EL PASO COUNTY GRADING AND EROSION CONTROL PLAN CHECKLIST

EPC Project Number: PUDSP-22-005

COUNTY FILE NO.:
PUDSP-22-005

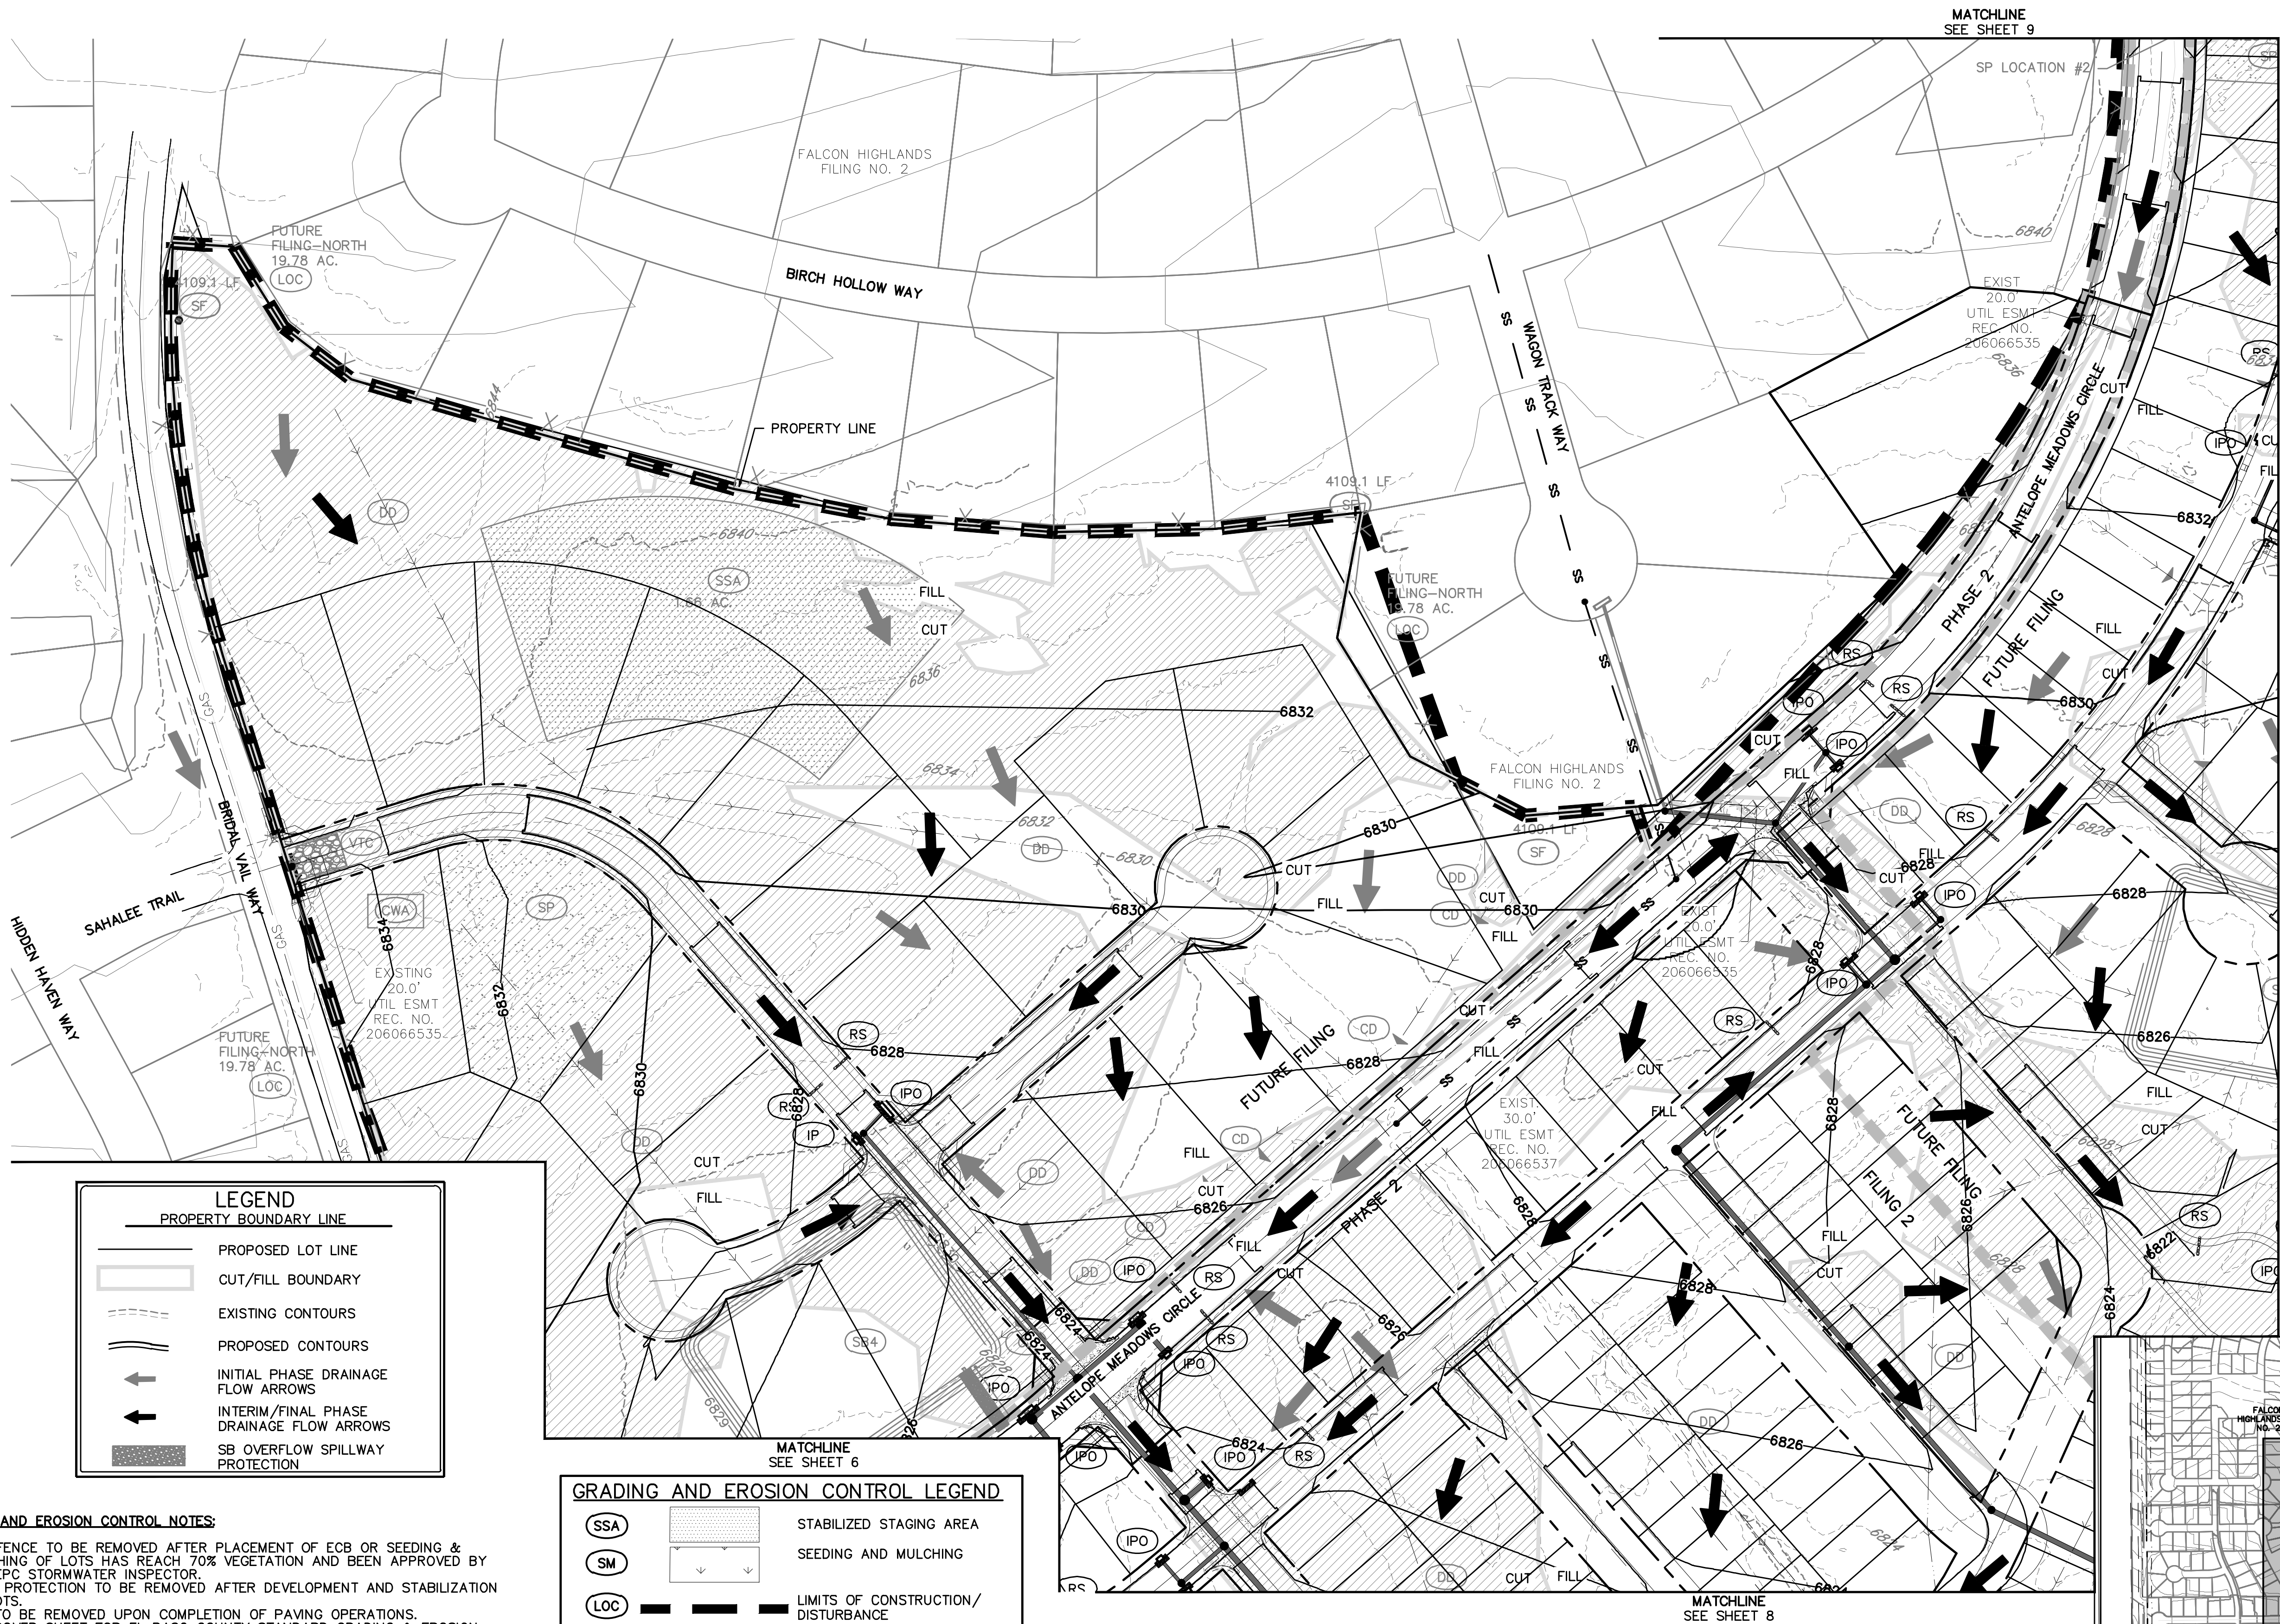
l	Existing and proposed contours 2 feet or less (except for hillside)		✓
m	Limits of disturbance delineating all anticipated areas of soil disturbance		✗
n	Identify and protect areas outside of the construction site boundary with existing fencing, construction fencing or other methods as appropriate		✗
o	Off-site grading clearly shown and called out		N/A
p	Areas of cut and fill identified		✓
q	Conclusions from soils/geotechnical report and geologic hazards report incorporated in grading design (slopes, embankments, materials, mitigation, etc.)		✓
r	Proposed slopes steeper than 3:1 with top and toe of slope delineated. Erosion control blanketing or other protective covering required		✓
s	Stormwater flow direction arrows		✓
t	Location of any dedicated asphalt / concrete batch plants		N/A
u	Areas used for staging, storage of building materials, soils (stockpiles) or wastes. The use of construction office trailers requires PCD permitting		✓

v	All proposed temporary construction control measures, structural and non-structural. Temporary construction control measures shall be identified by phase of implementation to include "initial," "interim," and "final" or shown on separate phased maps identifying each phase		✓
w	Vehicle tracking provided at all construction entrances/exits. Construction fencing, barricades, and/or signage provided at access points not to be used for construction		✗
x	Temporary sediment ponds provided for disturbed drainage areas greater than 1 acre		✓

4. APPLICANT COMMENTS			
a			✗
b	this does not match the TSB locations shown on the GEC		
c
